YG-DCO-092(B)

Yorkshire Green Energy Enablement (GREEN) Project

Document 5.2.19(B) Environmental Statement Consolidated Errata

Planning Inspectorate Reference: EN020024

Figure 1.8 – Proposed alternative access from the west, using an existing bridge over Cock Beck, and through the field associated with Lead Church.

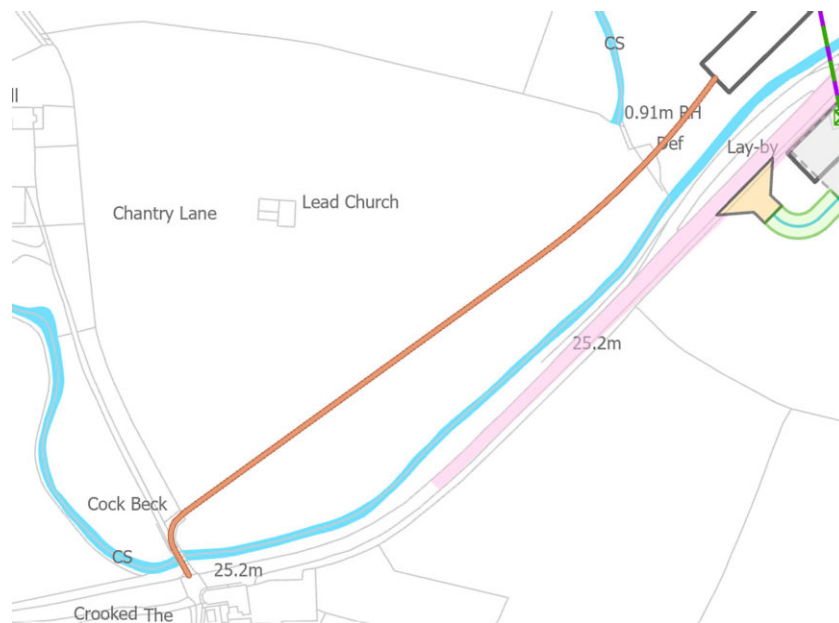
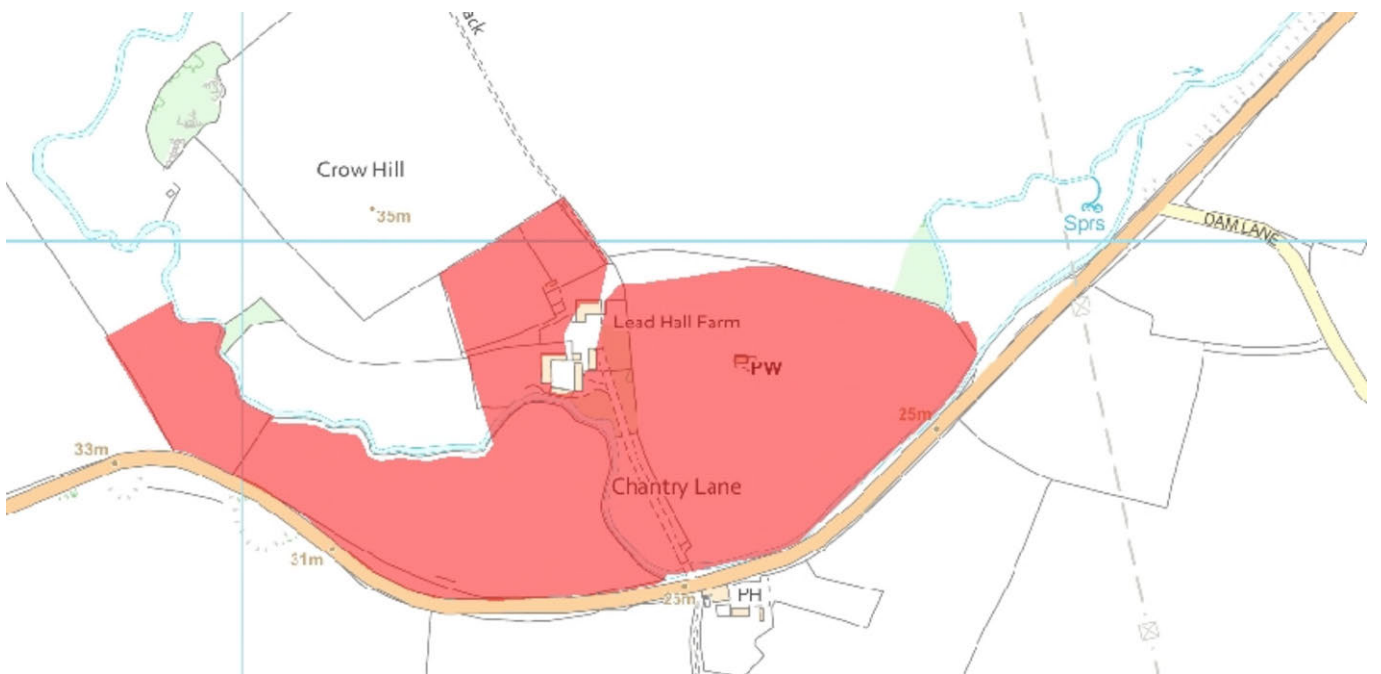
DCO Document Reference	Amendment/Clarification	Reason
<p>APP-095 (Document 5.3.3B), ES Appendix 3B Code of Construction Practice</p>	<p>Row HE03 of Table 3.3 is amended to read: <i>“Trackway to be installed as per the mitigation set out in Section 2.4 in ES Appendix 7G Technical Note for Scheduled Monument at Lead (ES Appendix 5.3.7G, Volume 5, Document 5.3.7G).”</i></p>	<p>Appendix description, name and reference number included in row HE03 of Table 3.3 Historic environment good construction practice measures, of Appendix 3B Code of Construction Practice (Document 5.3.3B [APP-095]) was incorrect. The correct description, name and reference number is provided.</p> <p>This will be incorporated into an update to the Code of Construction Practice (Document 5.3.3B) [APP-095] at a future deadline as it is secured under Requirement 5 and is a certified document under Article 48 of the draft DCO (Document 3.1(B)) [AS-011].</p>
